Development Facilitation Team (DFT) – Review Comments

Project No: PR-2024-009765 Date: 4/2/2025 Agenda Item: #1 Zone Atlas Page:

Request: Major Amendment to existing EPC Site Plan for Subdivision – Gateway Center

Location: 1100 Woodward Pl NE

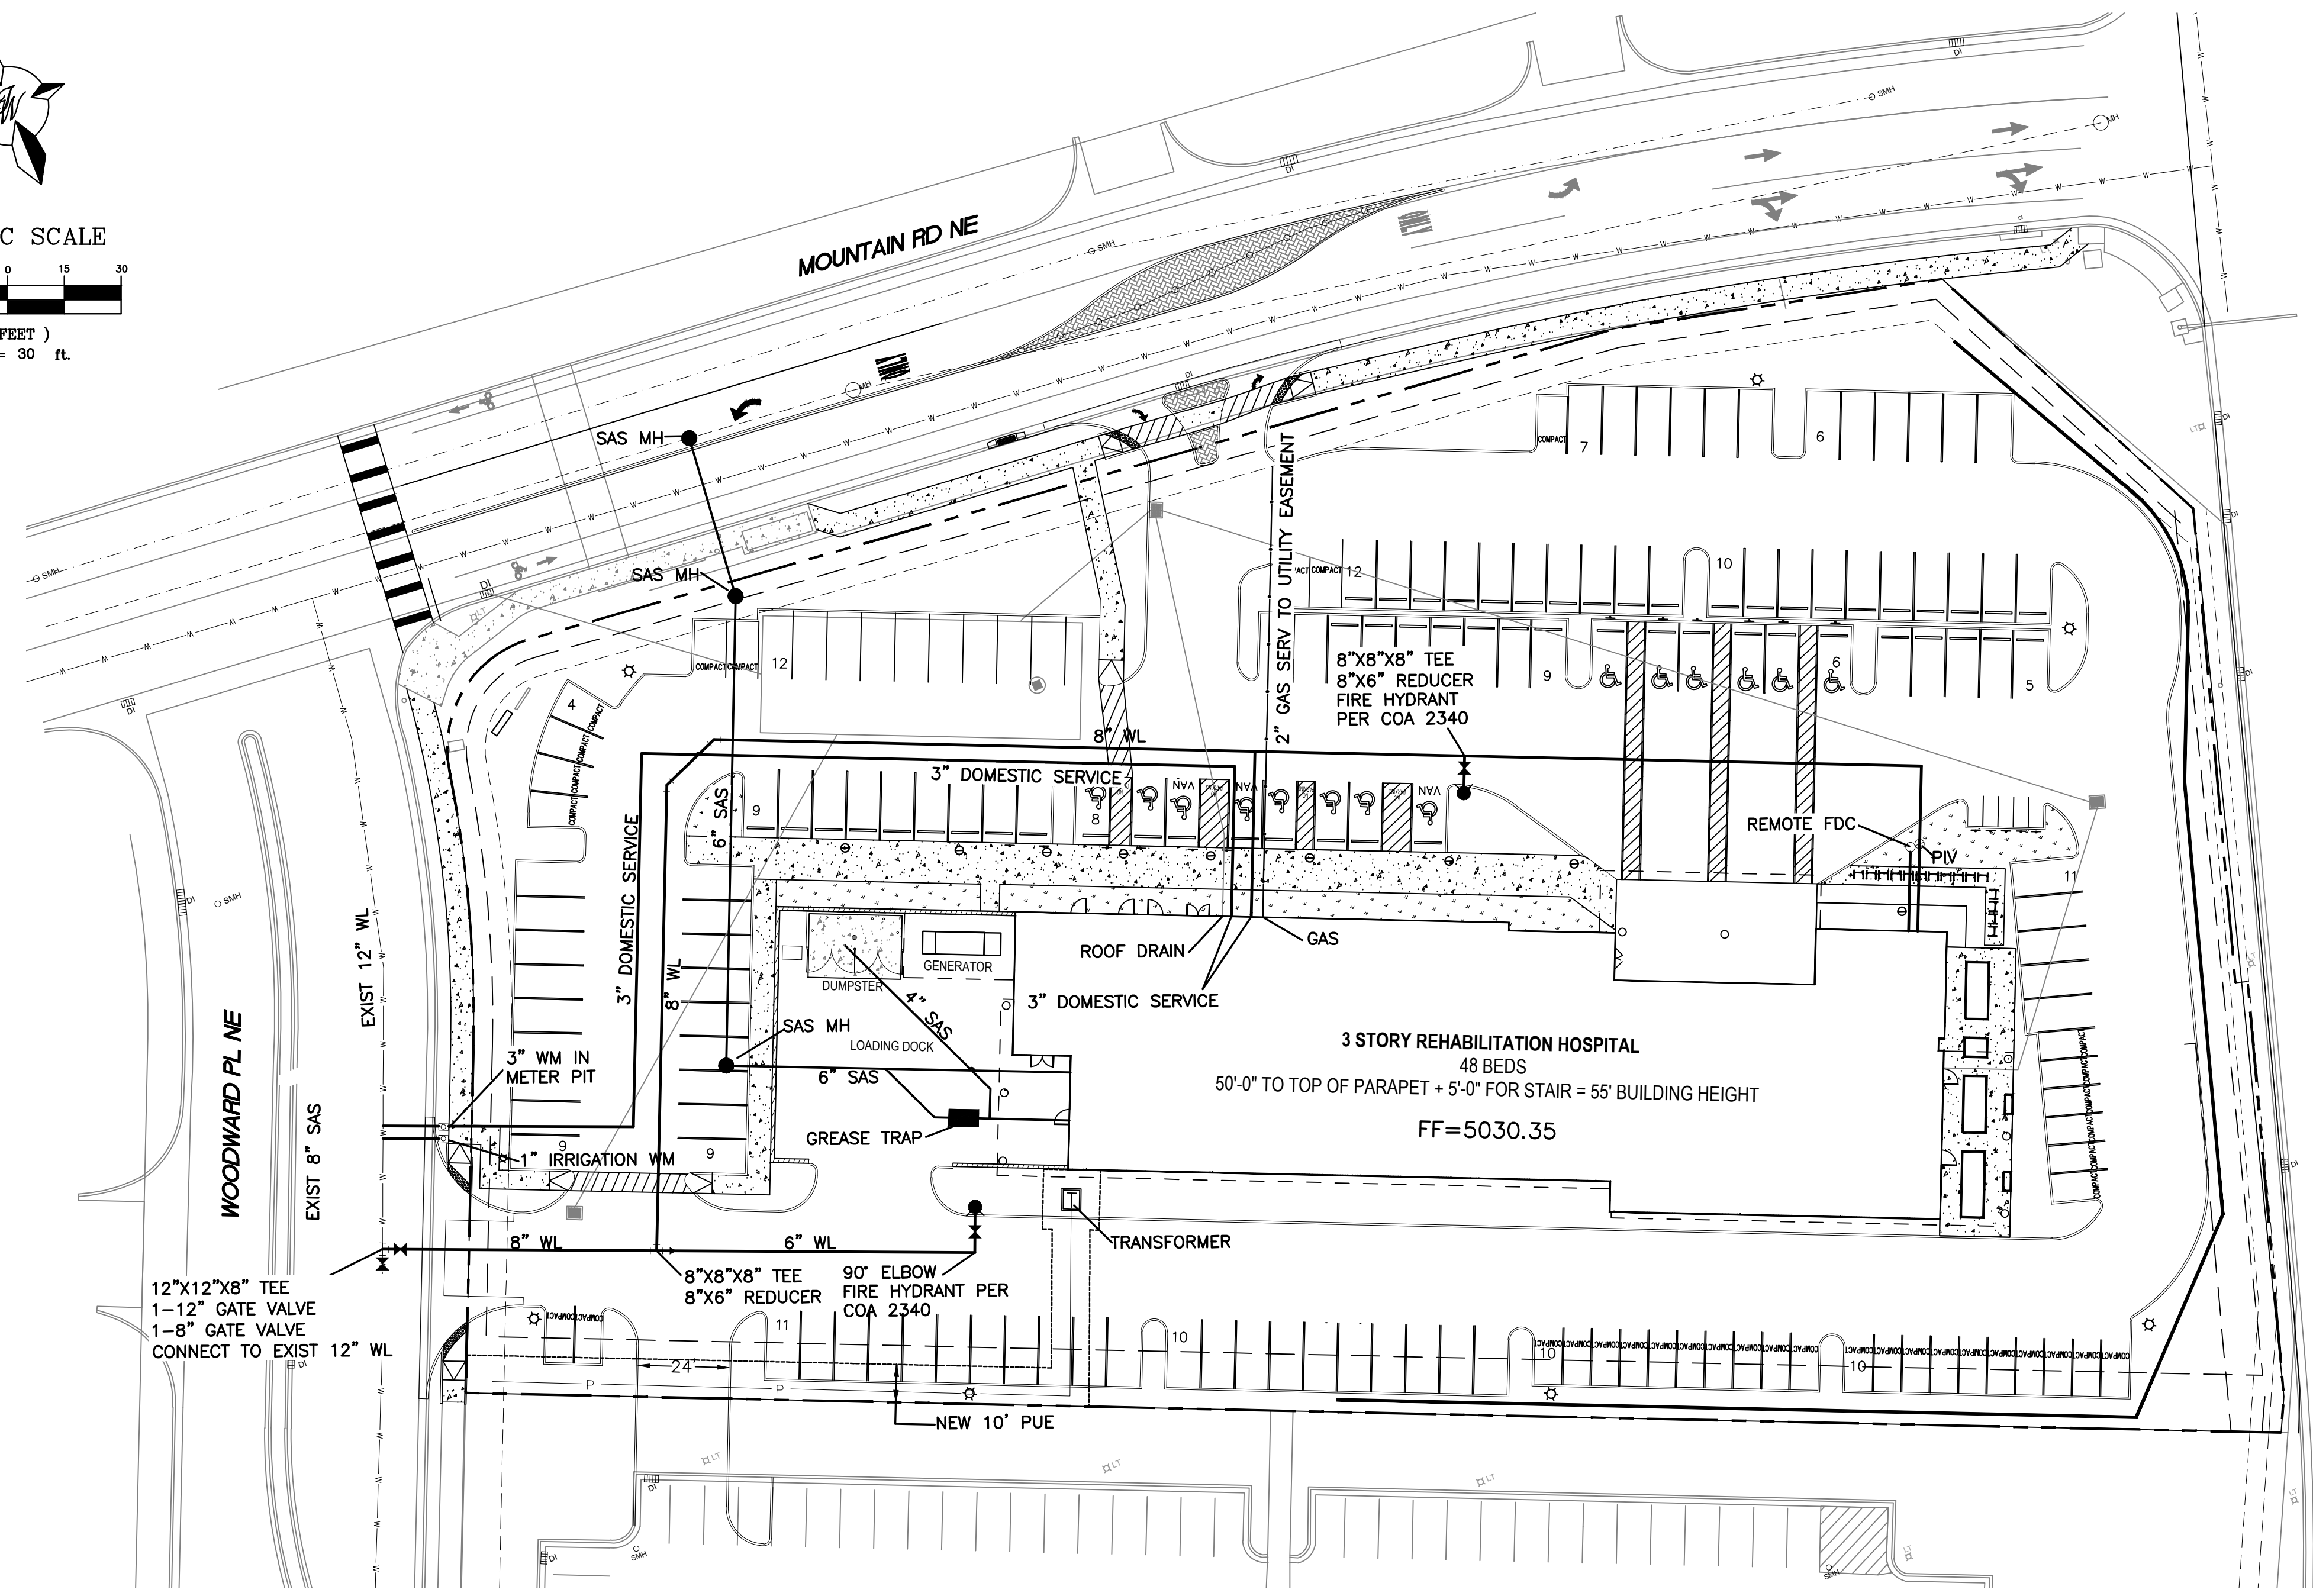
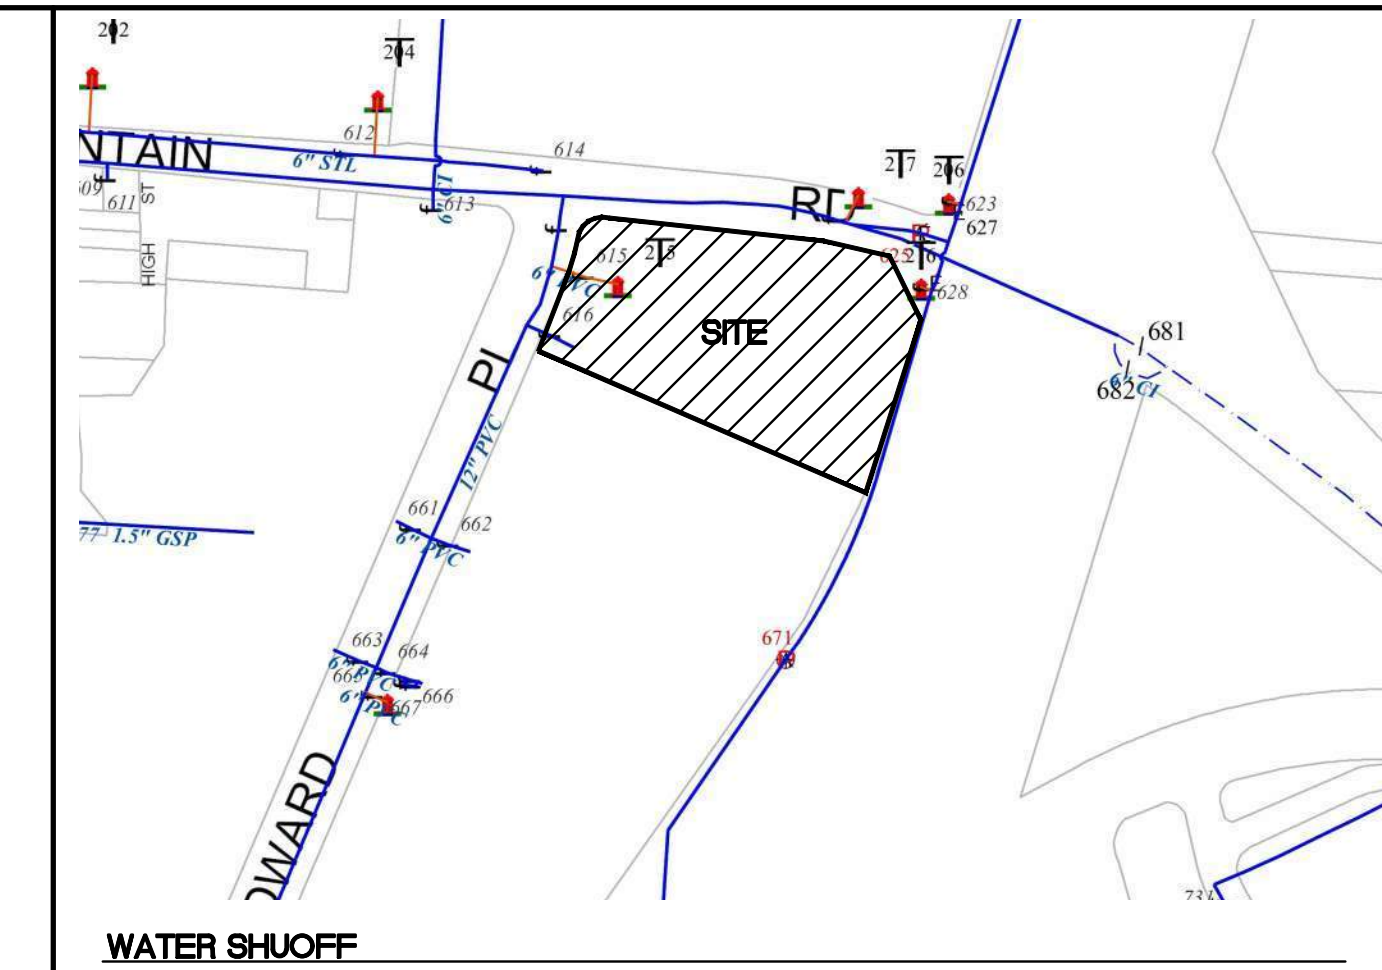
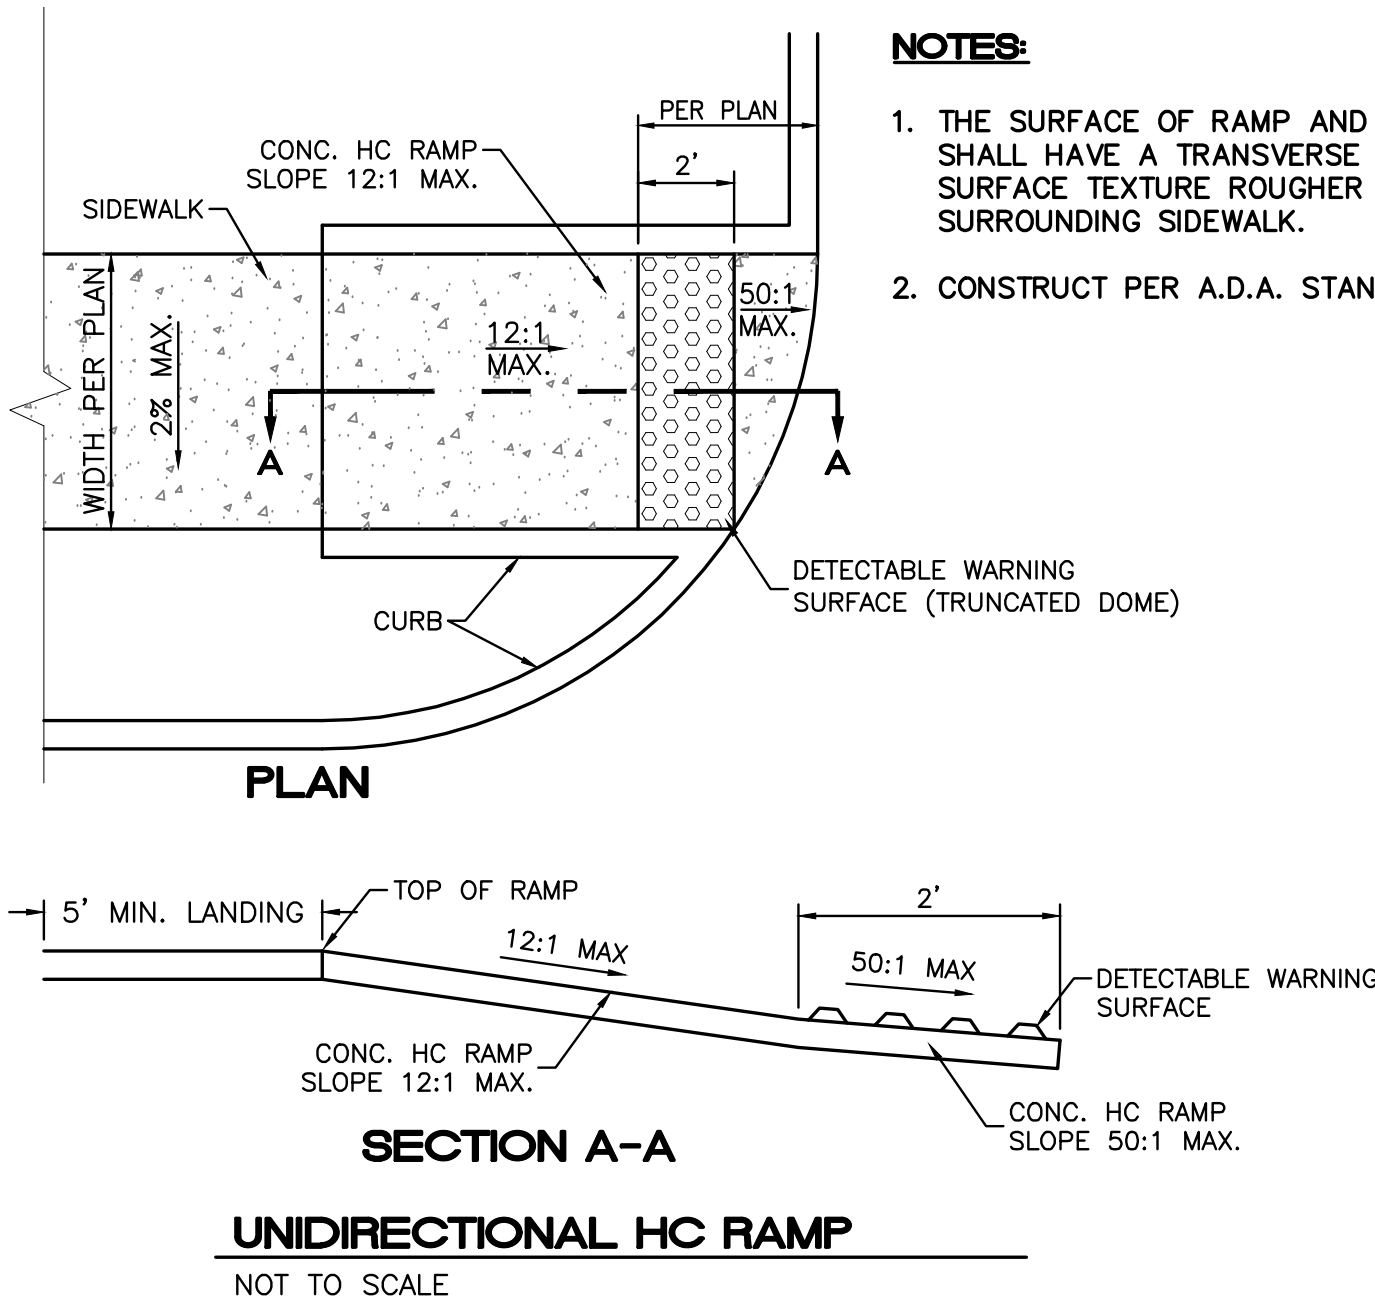
1. The following notes need to be added to the Master Utility Plan and the subsequent Site Plan submittal for review and approval by the DFT:
 - a. “Coordination with Water Authority Cross Connection Section will be required to ensure proper backflow containment is in place prior to release of meter for the site. Contact the Cross Connection Section at 505-289-3454.”

- b. “Coordination with the Water Authority Pre-Treatment Engineer is required to ensure the site complies with Water Authority Sewer Use Ordinance. Contact the Pre-Treatment Engineer at 505-289-3439.”

- c. Under General Utility Notes, replace statement under Note 6 with the following: “Fire, domestic, and irrigation lines must have backflow preventors per the ABCWUA Cross Connection Ordinance.”

2. Comment - the symbology included in the legend for the new SAS manhole and for the new water meter do not match the symbology used on the plan. Please revise.

This was corrected on sheet MU-1

These notes were
added to sheet MU-1
